CITY OF ALBUQUERQUE

July 16, 2019

Re: Champion Xpress Car wash
4516 Wyoming Blvd NE, 87111
Traffic Circulation Layout
Engineer's/Architect's Stamp 7-15-19 (F20D005)

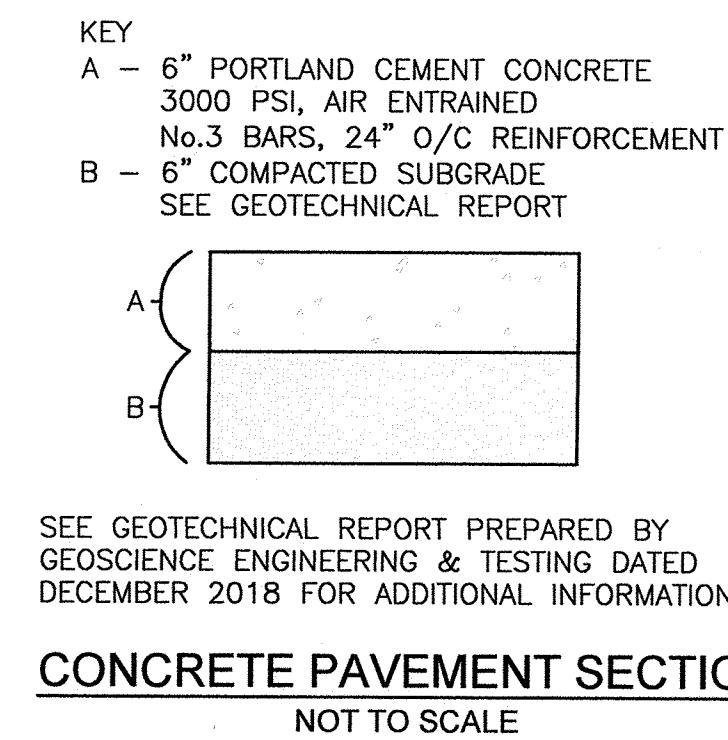
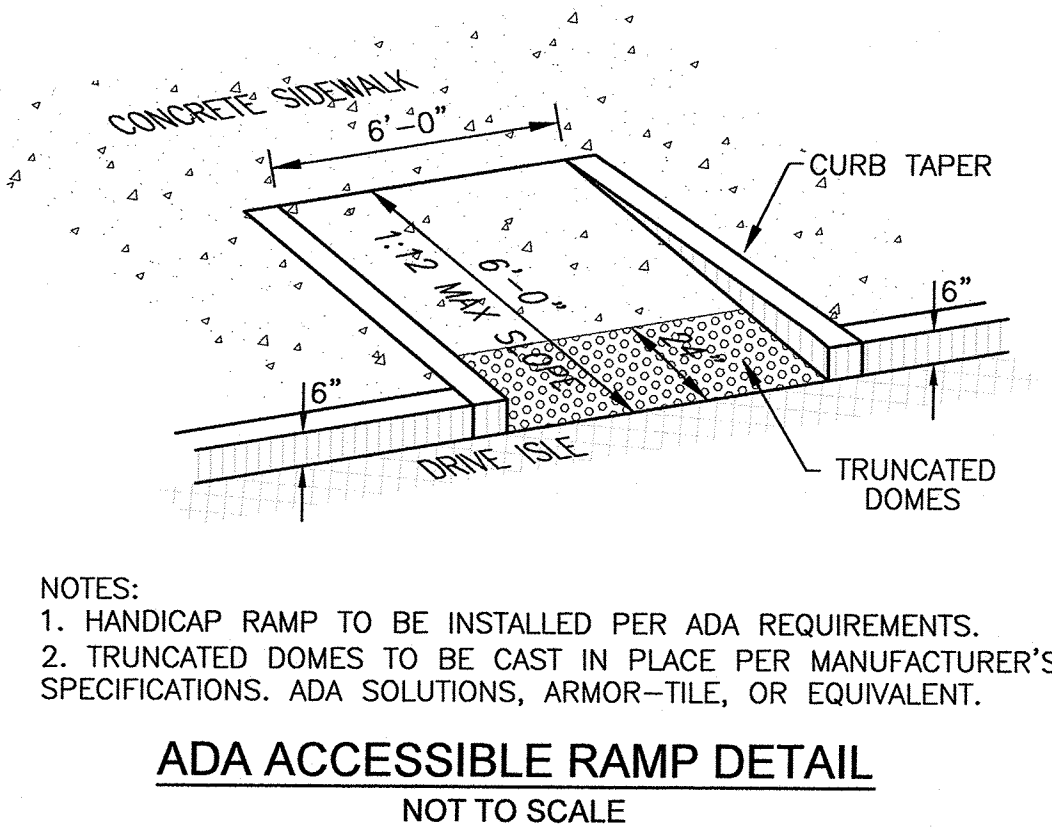
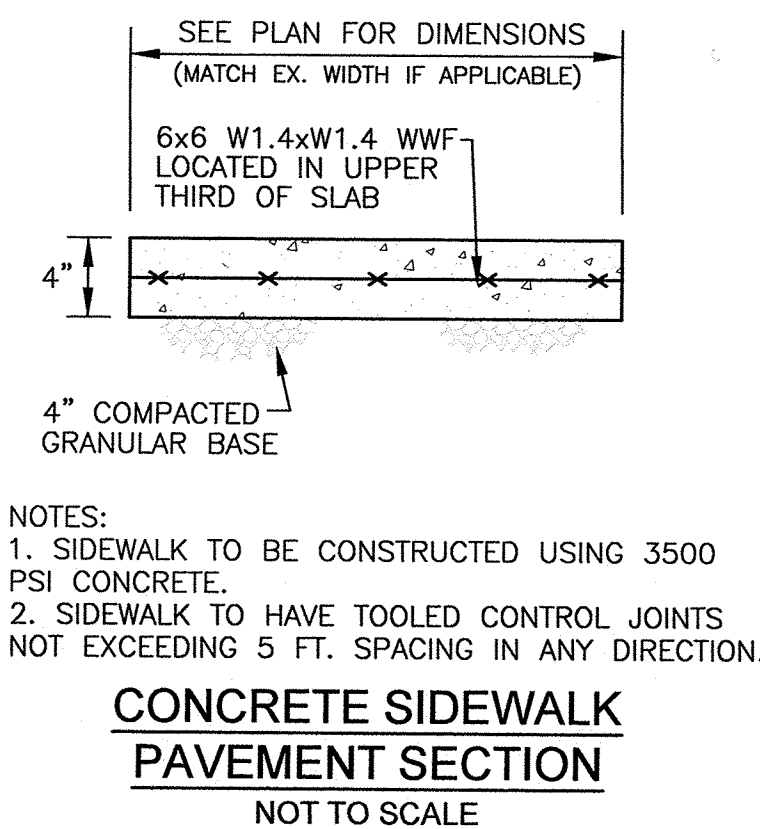
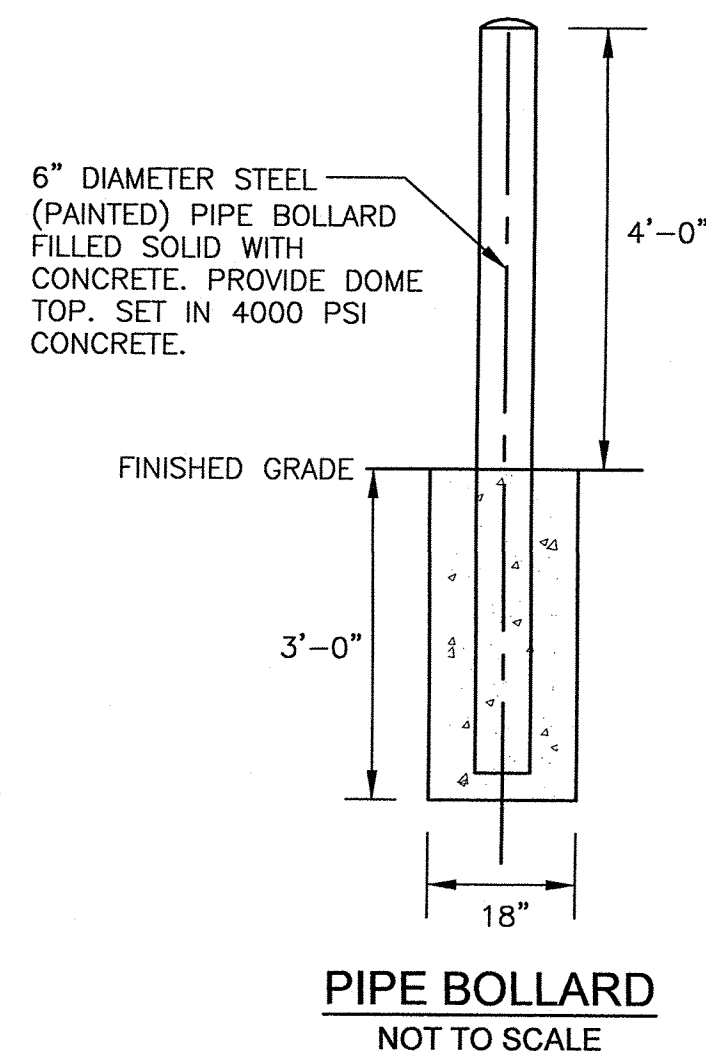
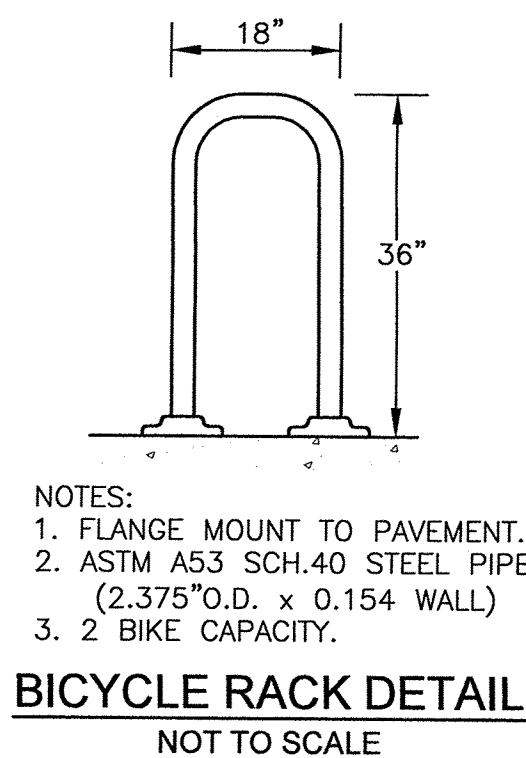
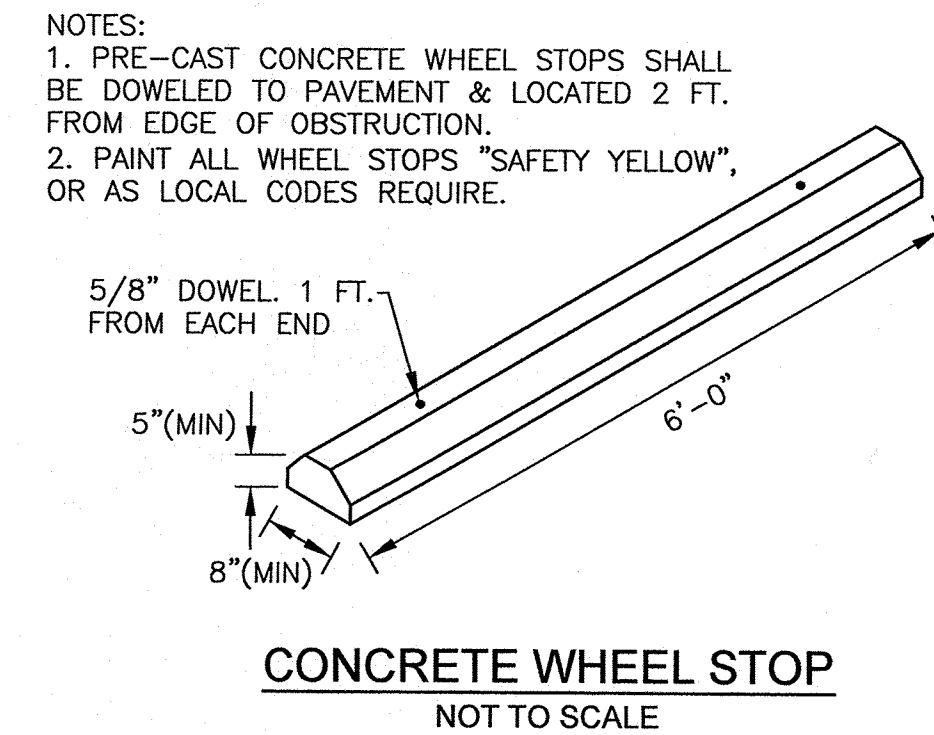
1. Prior to release of Final CO. Please add ADA ramp on west side of ADA pathway in front of exit stop bar.
